FORSMAN ENGINEERING

JOB 19026 Sluicer Basin Const - Commencement

SHEET NO. Add 1 OF Add Cycle 2

Restrained Retaining Walls -

SD2

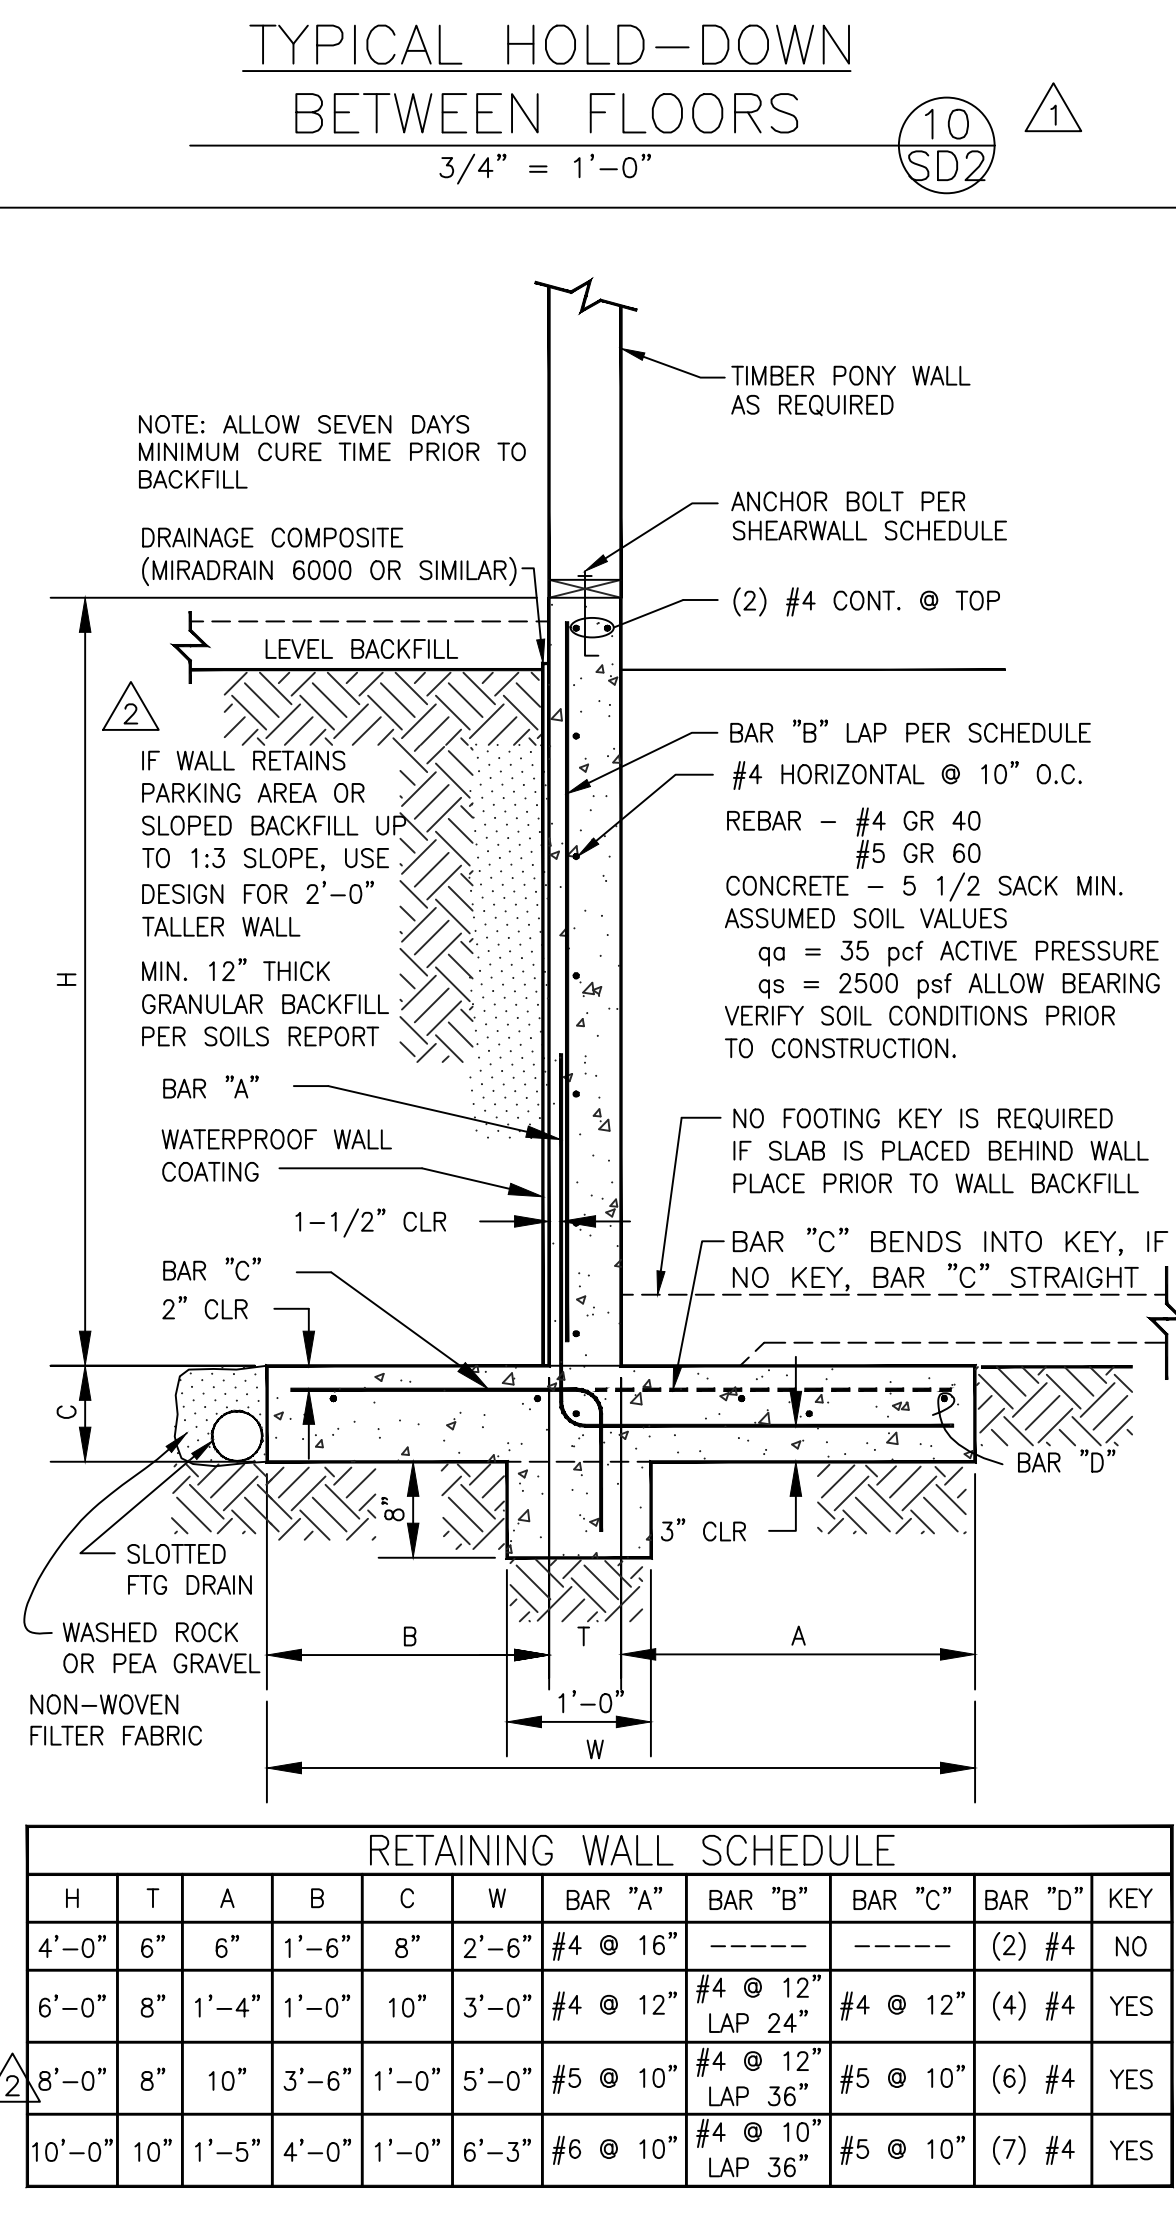
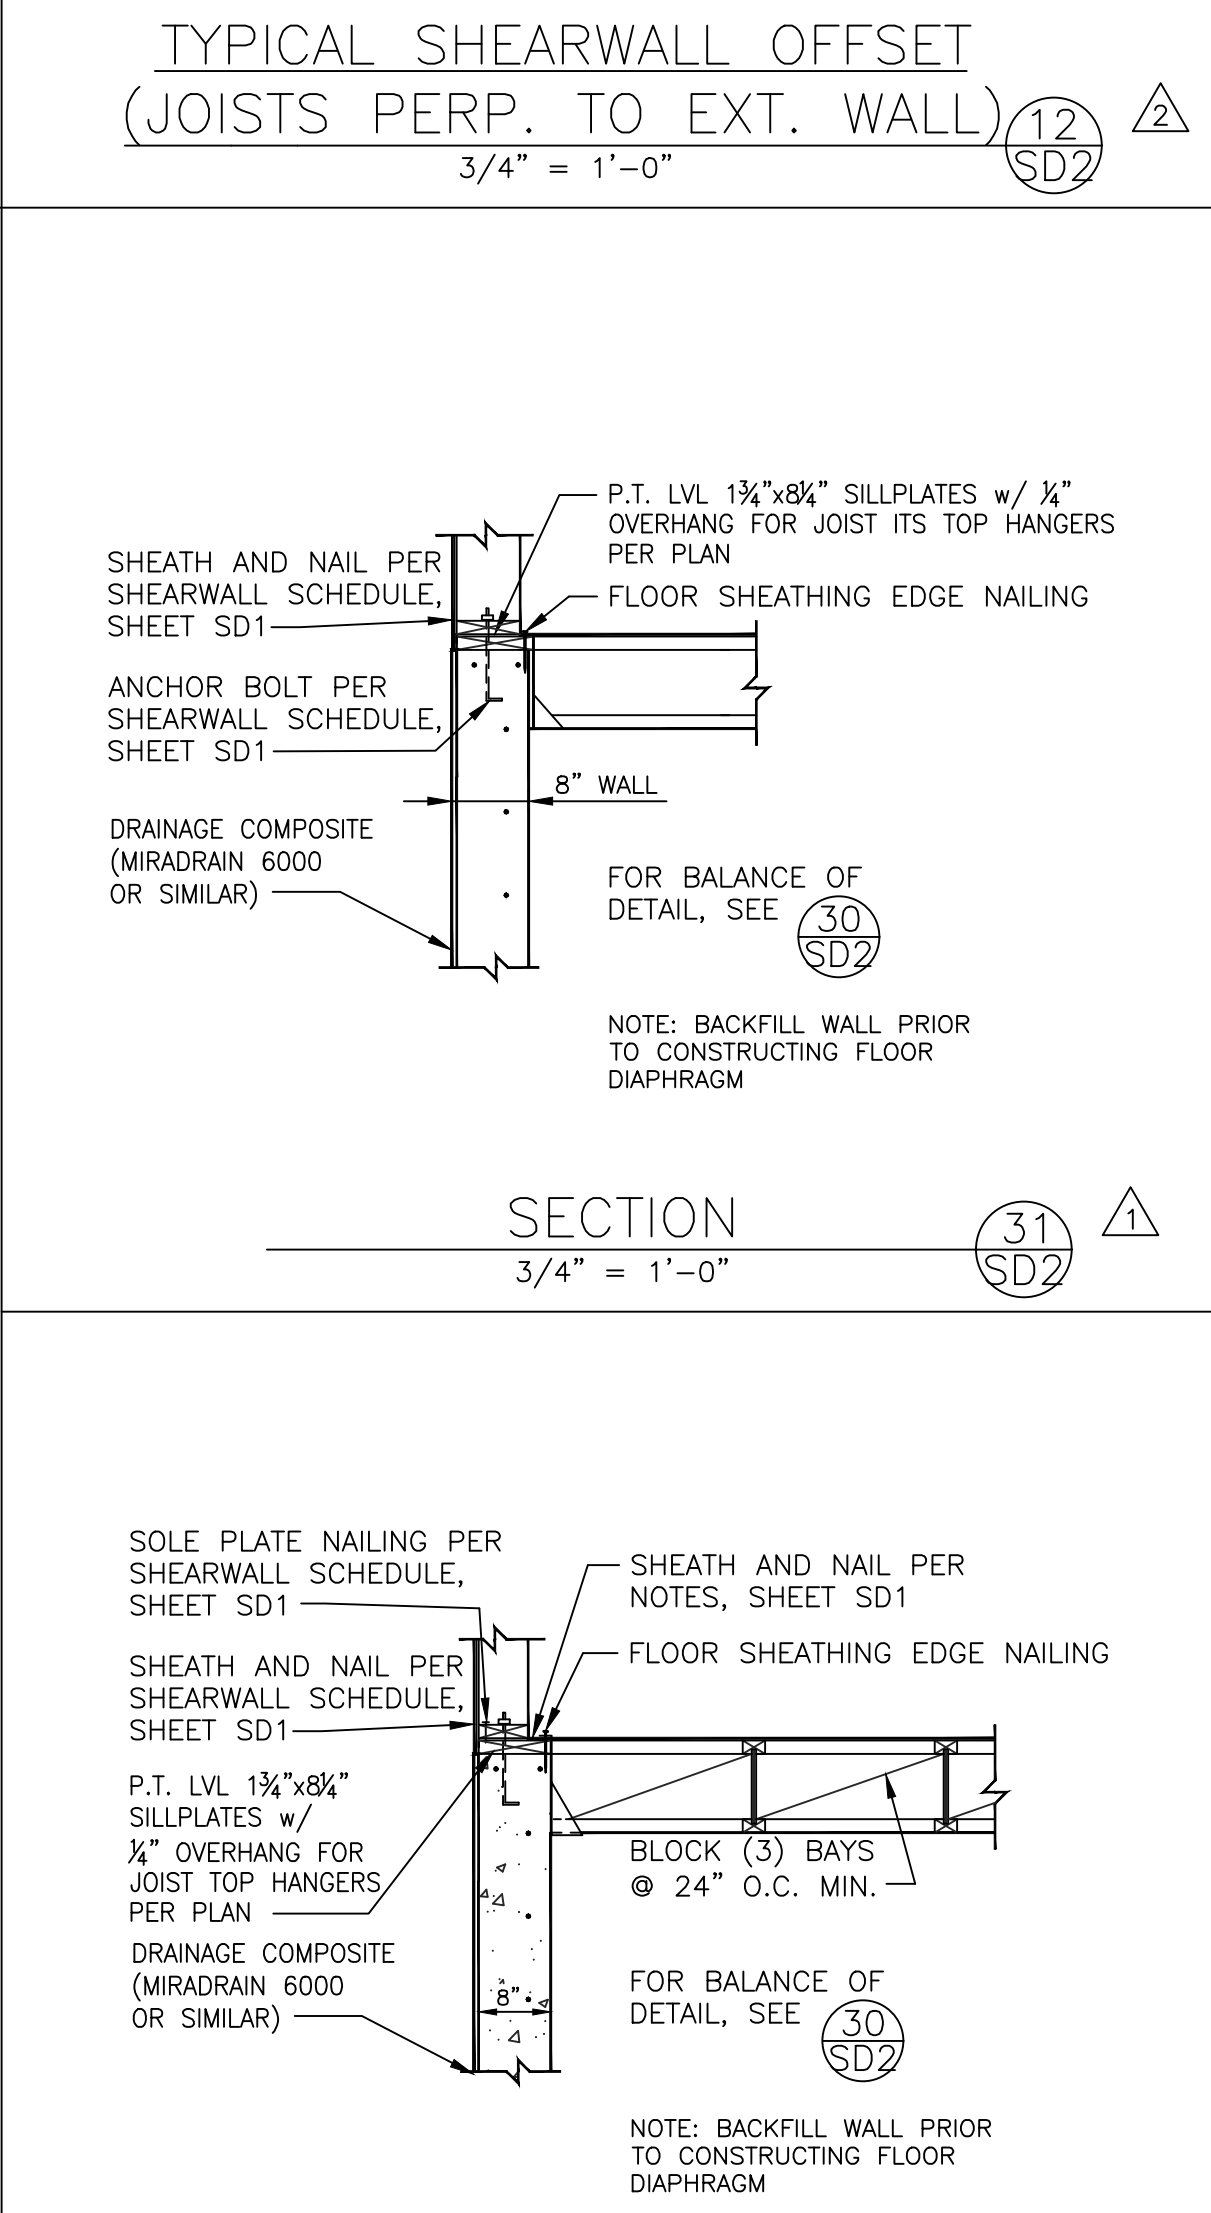
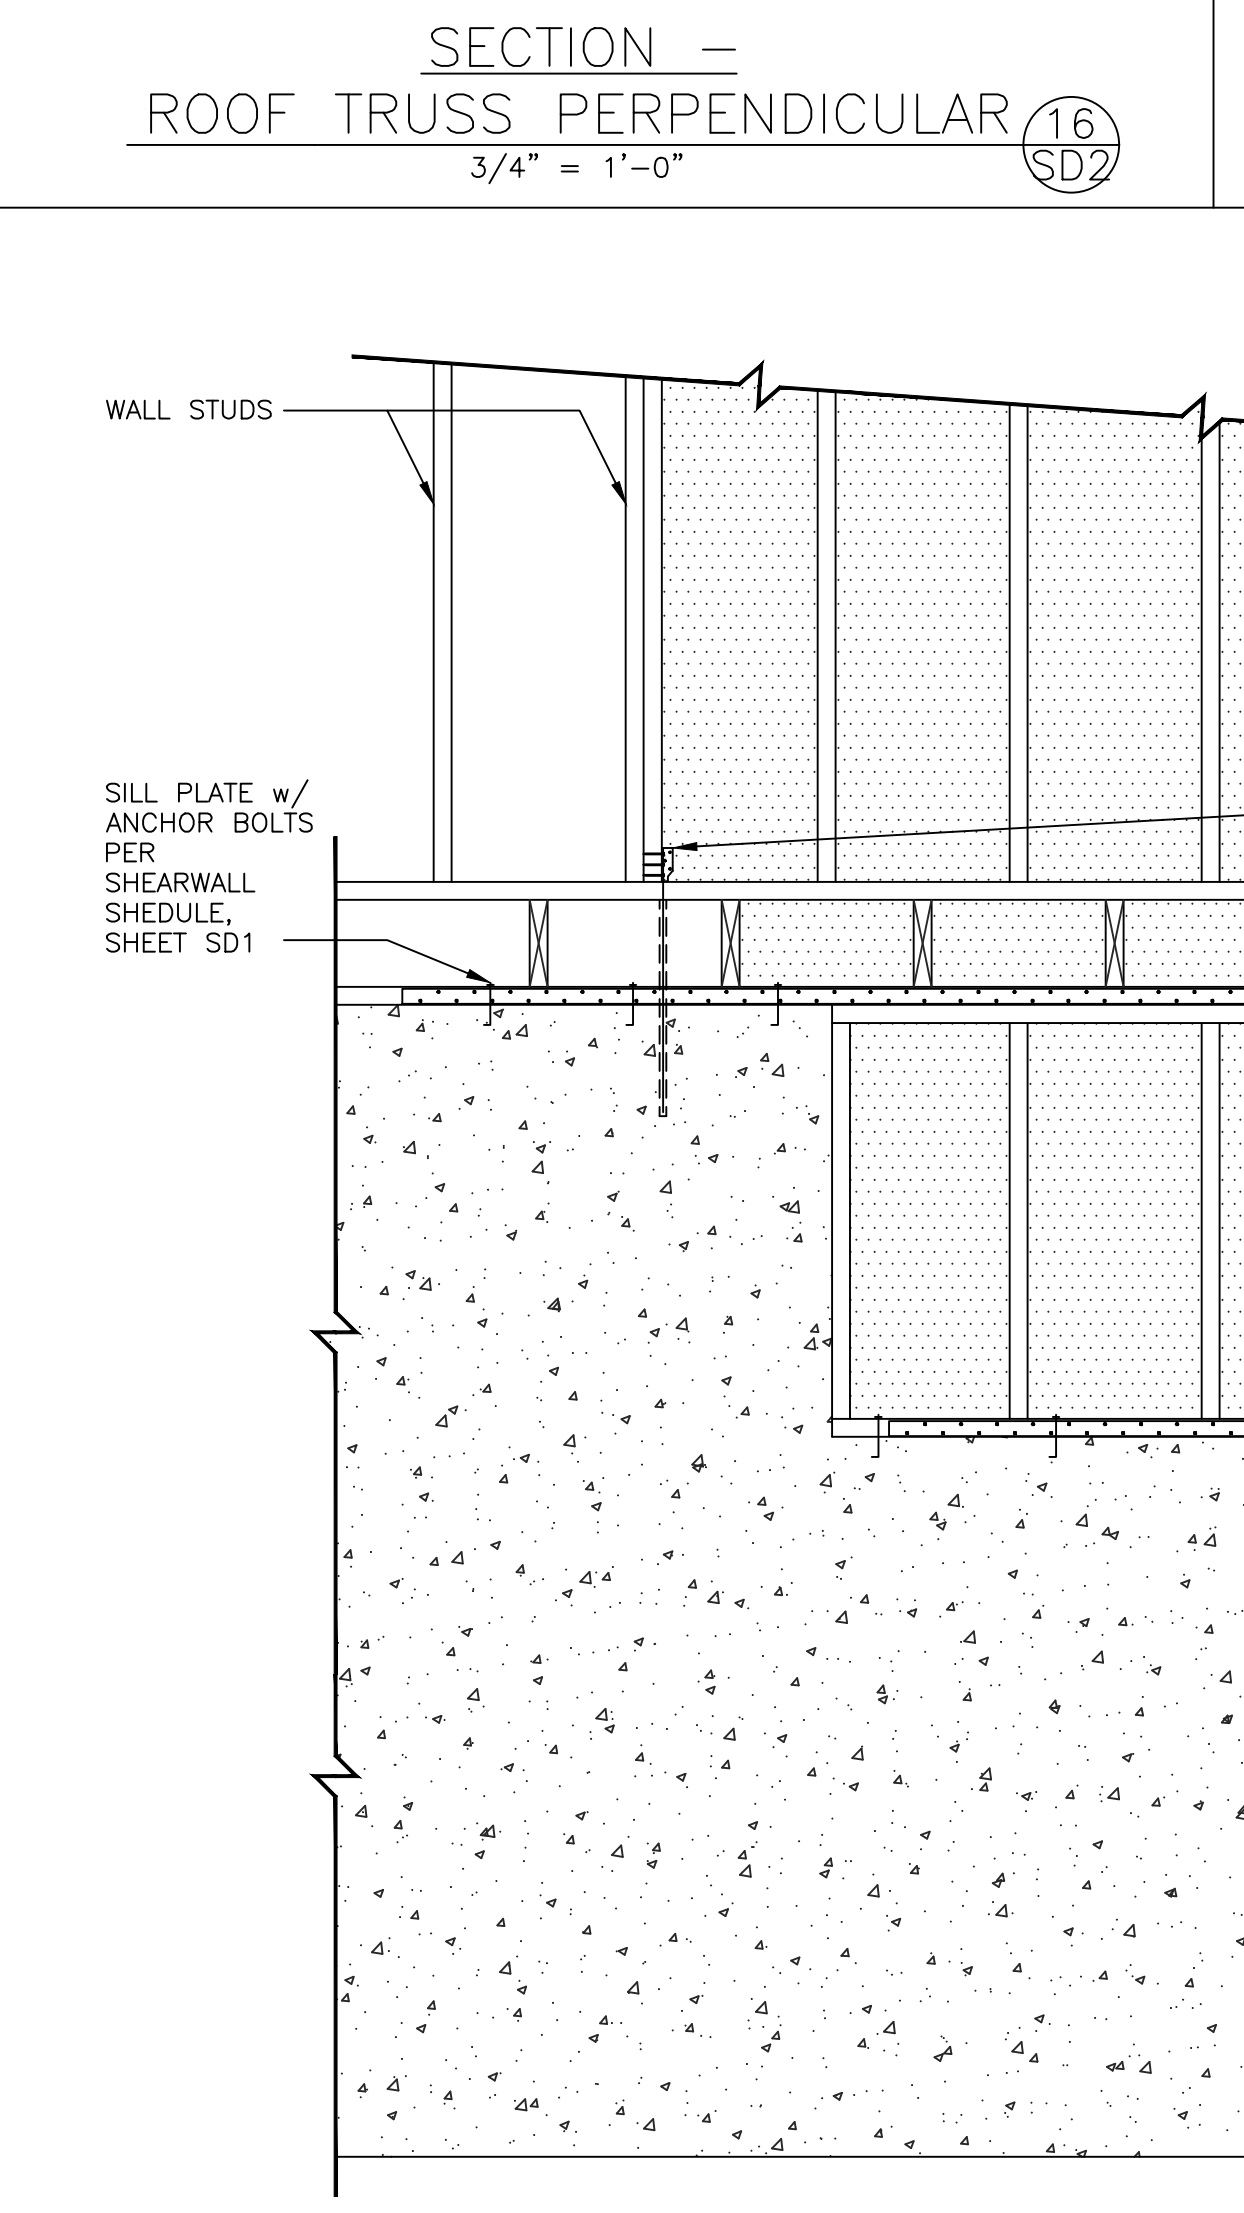
Reference Geotech report JN16448 page 5. As noted in report and confirmed 12-9-20 w/ Rob Ward, the previously un-restrained walls that have been designed w/ 35pcf are fine for stability but when within 1.5h of perpendicular wall additional steel may be required to reduce cracking; therefore, walls have been reviewed below to assure steel will be sufficient for an additional 10pcf x height of wall to the un-restrained active EFP.

Well height	10h	Design Wall height add	Wall design h'
4'	40	40 / 35 = 1.14	5.14
6'	60	60 / 35 = 1.71	7.71
8'	80	80 / 35 = 2.29	10.29
10'	100	100 / 35 = 2.86	12.86

Reinforcing is function of moment, Moment = wh²/6 so only variable h changes; hence, review ratio of

h'/h	Review 1.65 x Mo	Changes
$(5.14)/4^2 = 1.65$	✓	None
$(7.71)/6^2 = 1.65$	✓	None
$(10.29)/8^2 = 1.65$	✓	#5@10
$(12.86)/10^2 = 1.65$	✓	None

Also heel steel moment based on Mw / FS1 as printed, review w/ FS2
